Discharge of details (retail food store only) reserved by Full Planning Permission conditions 7 (highway details), 18 (drainage), 19 (watercourse investigation), 20 (surface water drainage scheme), 23 (waste collection), 25 (ecological design strategy), 26 (landscaping), 27 (arboricultural method statement) and 29 (boundary treatments) of previous Section 73 approval 2024/92395 for variation of condition 2 (plans and specifications) and 3 (phasing) of previous Section 73 approval 2023/93058 for variation of conditions 2 (plans) and 3 (phasing plan) of previous hybrid permission 2018/92647 for mixed use development - retail/office and 229 residential units (Use Classes C3/ E(a) /B1a)

Former Kirklees College site, New North Road, Huddersfield, HD1 5NN

Application Number: 2025/91021

Drawing Title: SITE BOUNDARY TREATMENT PLAN AND DETAILS

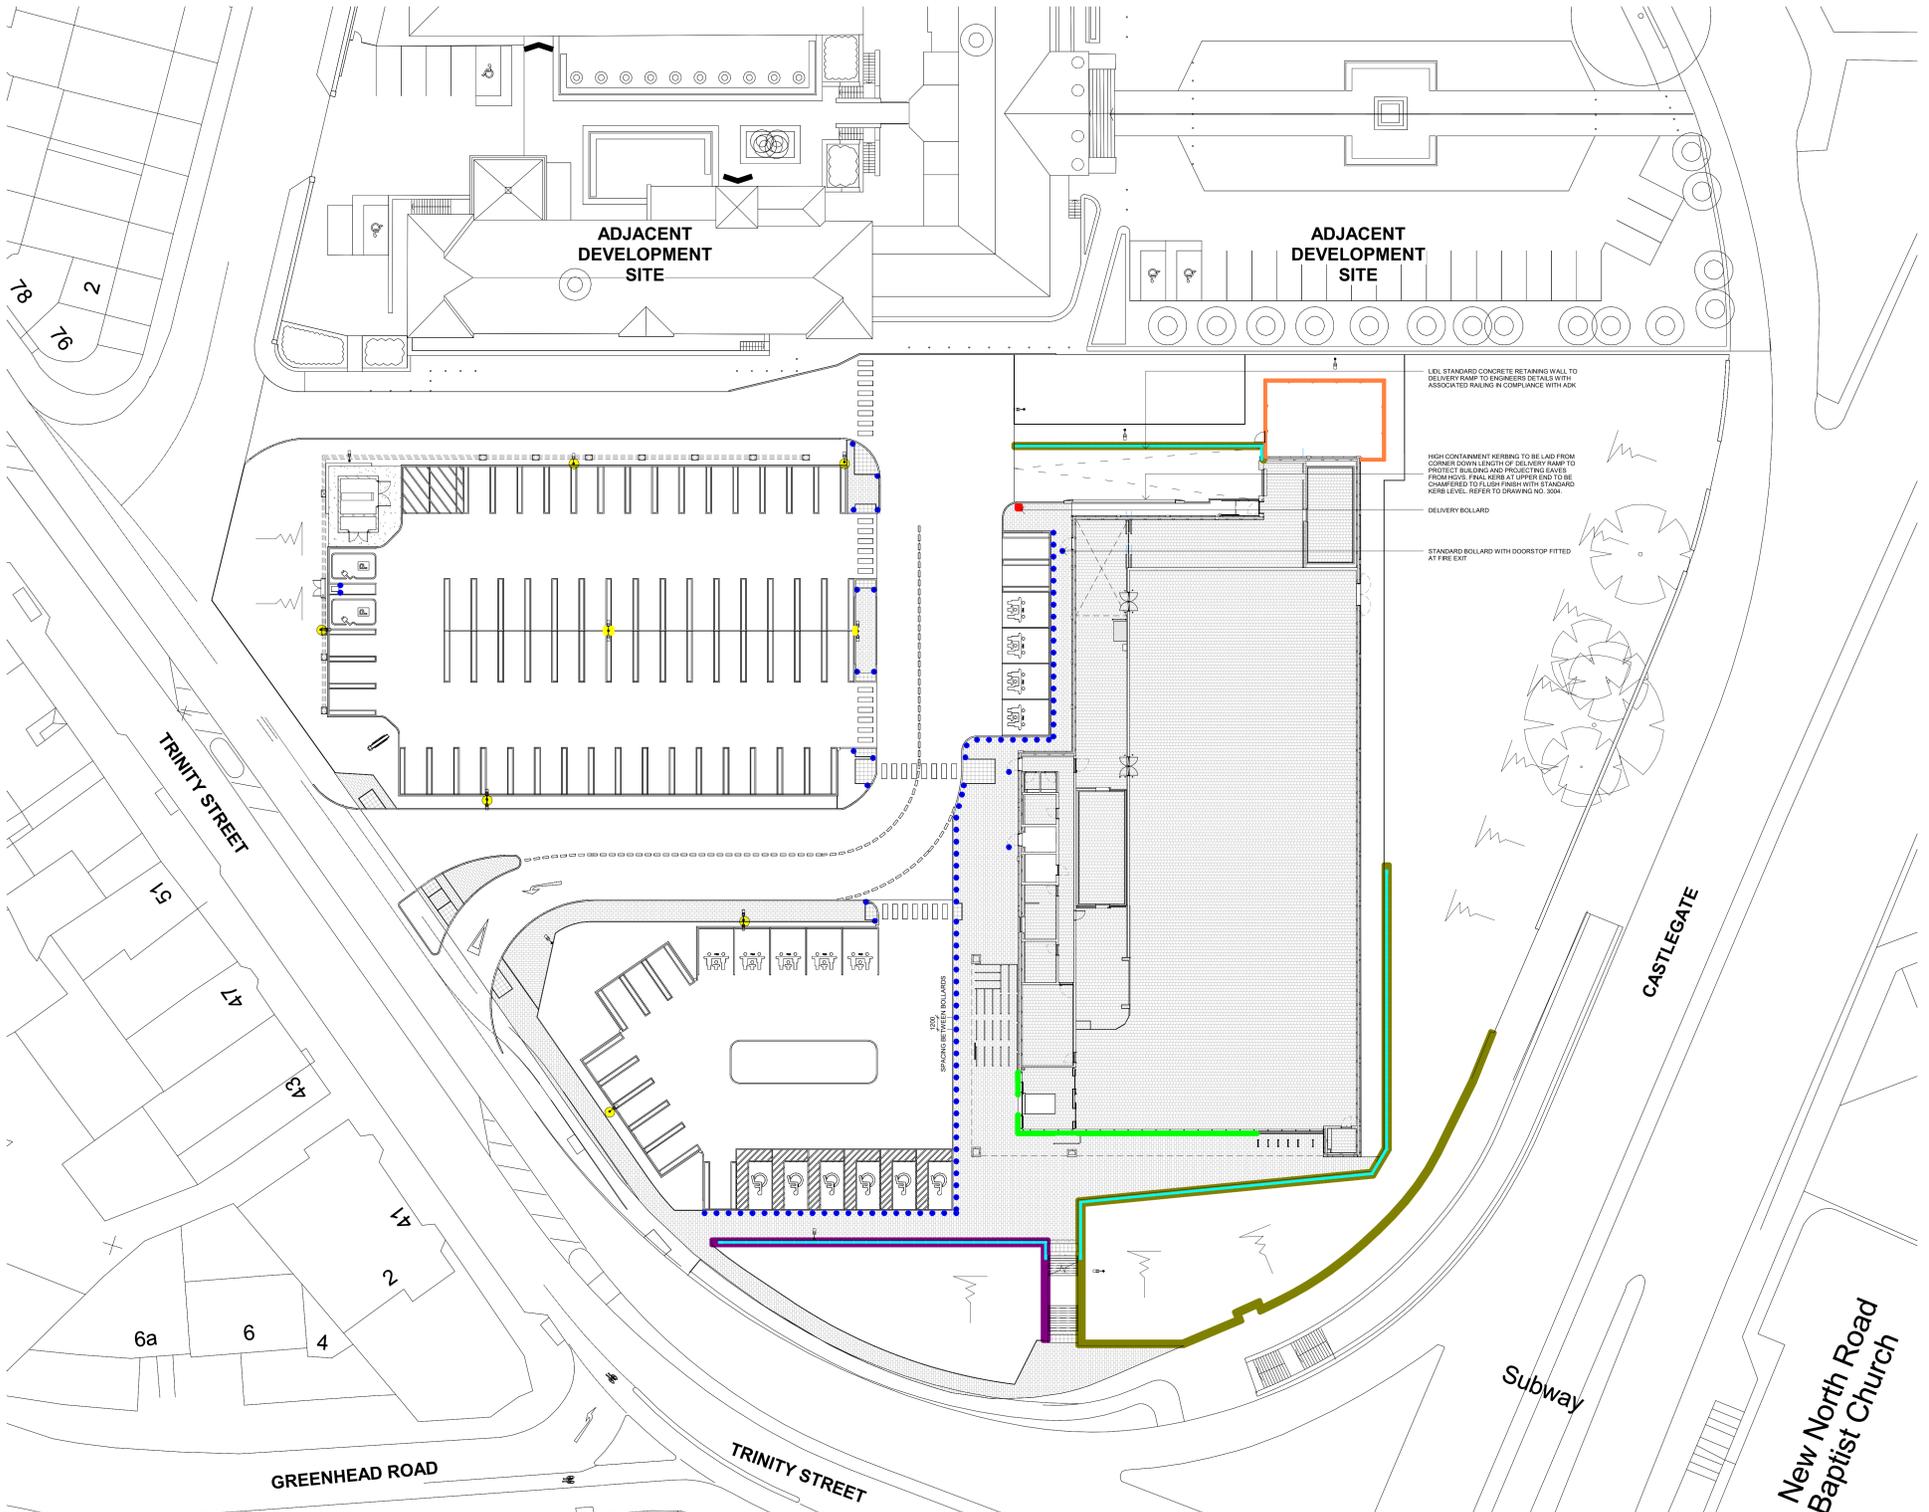
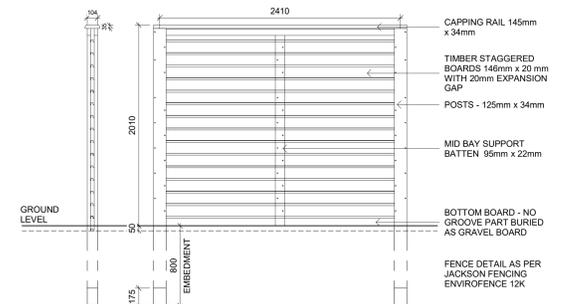
- Retaining walls adjacent to the footway at the southern end of the site, and within the site (south of the retail store and adjacent to the delivery bay).
- 1.1m high railings above some retaining walls.
- Stainless steel crash tubing to the southern end of the retail store.
- 2.01m high acoustic timber fence to the plant enclosure at the north end of the retail store.
- 1.1m high stainless steel bollards around and within the car park.
- 1.5m high stainless steel crash protection bollard adjacent to the delivery bay.

Only the acoustic timber fence has been illustrated in elevation. That elevation lacks information regarding the colour and finish of the timber, and the annotation referring to a “Jackson Fencing Envirofence 12K” is not supported by product information.

For the other boundary treatments, insufficient information (such as elevations or product sheets, and details of colours and finishes) has been submitted to demonstrate that visual and neighbouring amenity would be maintained, and that the significance and appearance of the site's listed buildings and the character and appearance of the Greenhead Park / New North Road, Huddersfield Town Centre and Springwood Conservation Areas would be maintained.
